Our ref. 2386

26/03/2019

EP/179/18/PL, Gladwyn, The Street, East Preston

Project: Proposed new homes; Gladwyn, The Street, East Preston BN16 1HT			
Drawing: Block plan, bin store elevations			
For: Mrs. J. Simmonds & Mr. P. Beamish			
Drawn: PKS		Date: November 2018	
Scales: 1:50 1:200		No: 2386/01/03/C	
To scale when printed on A3

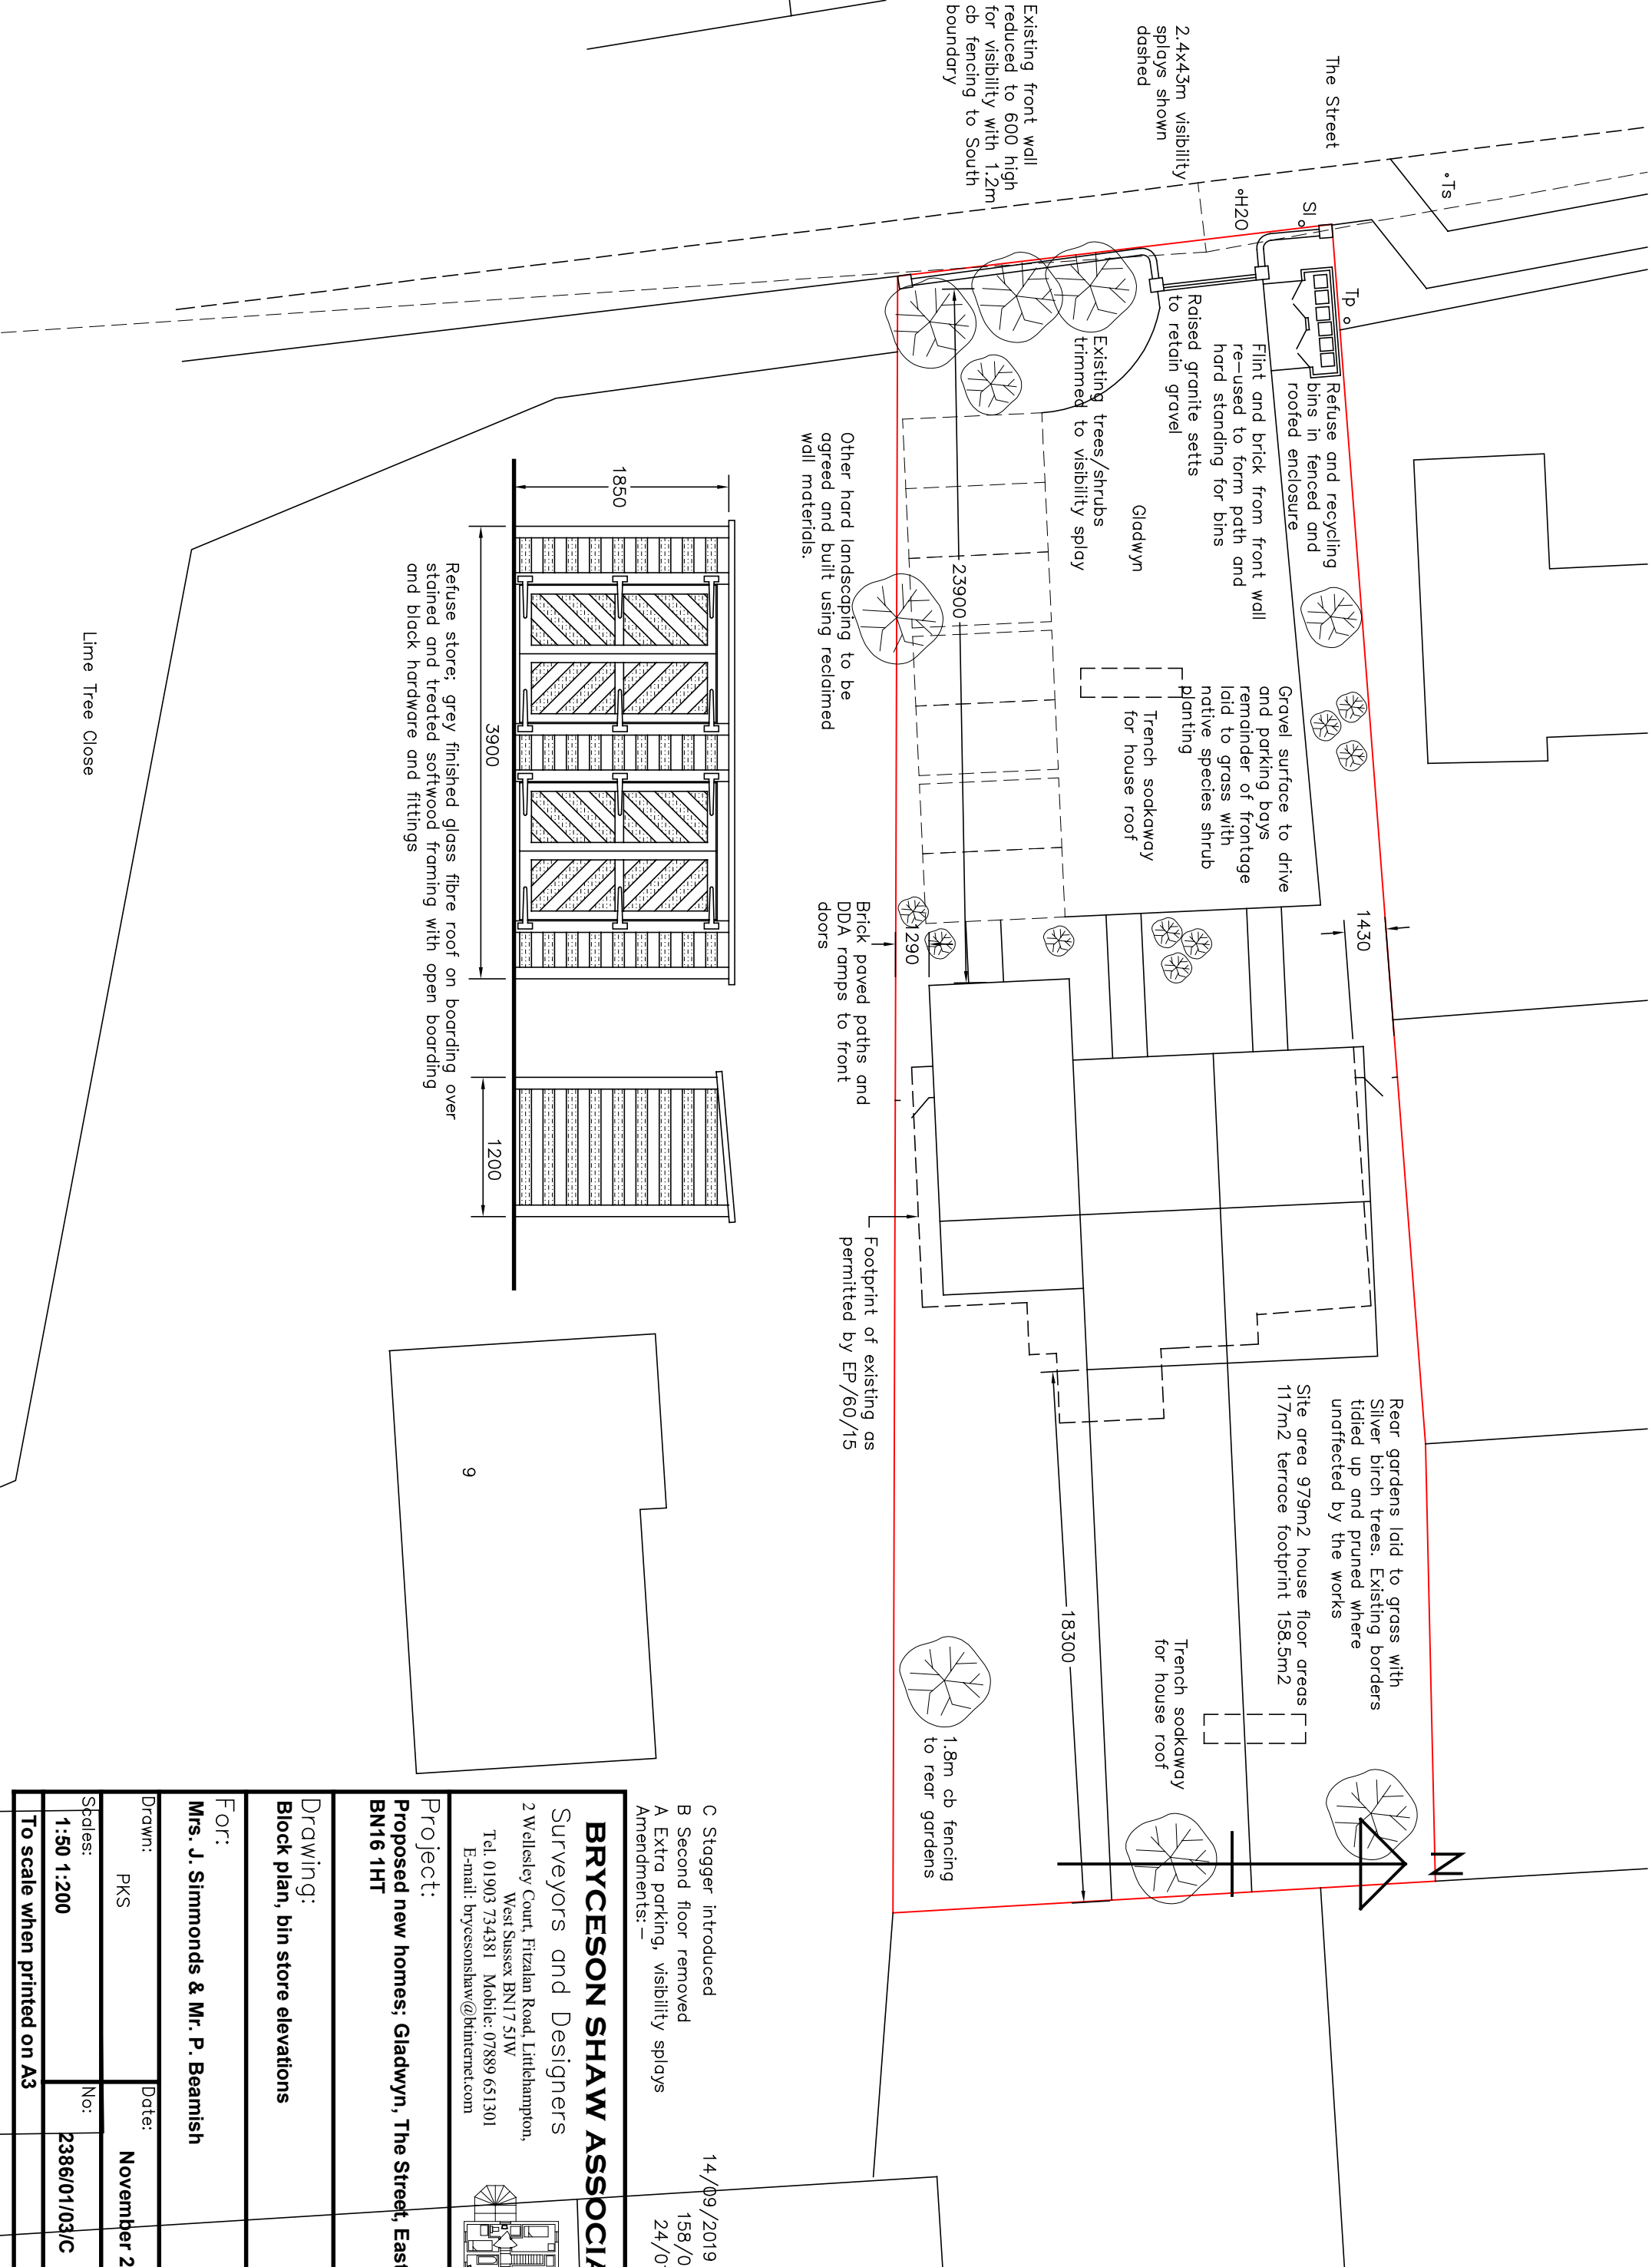
The porous paving to the parking area will be pea gravel.
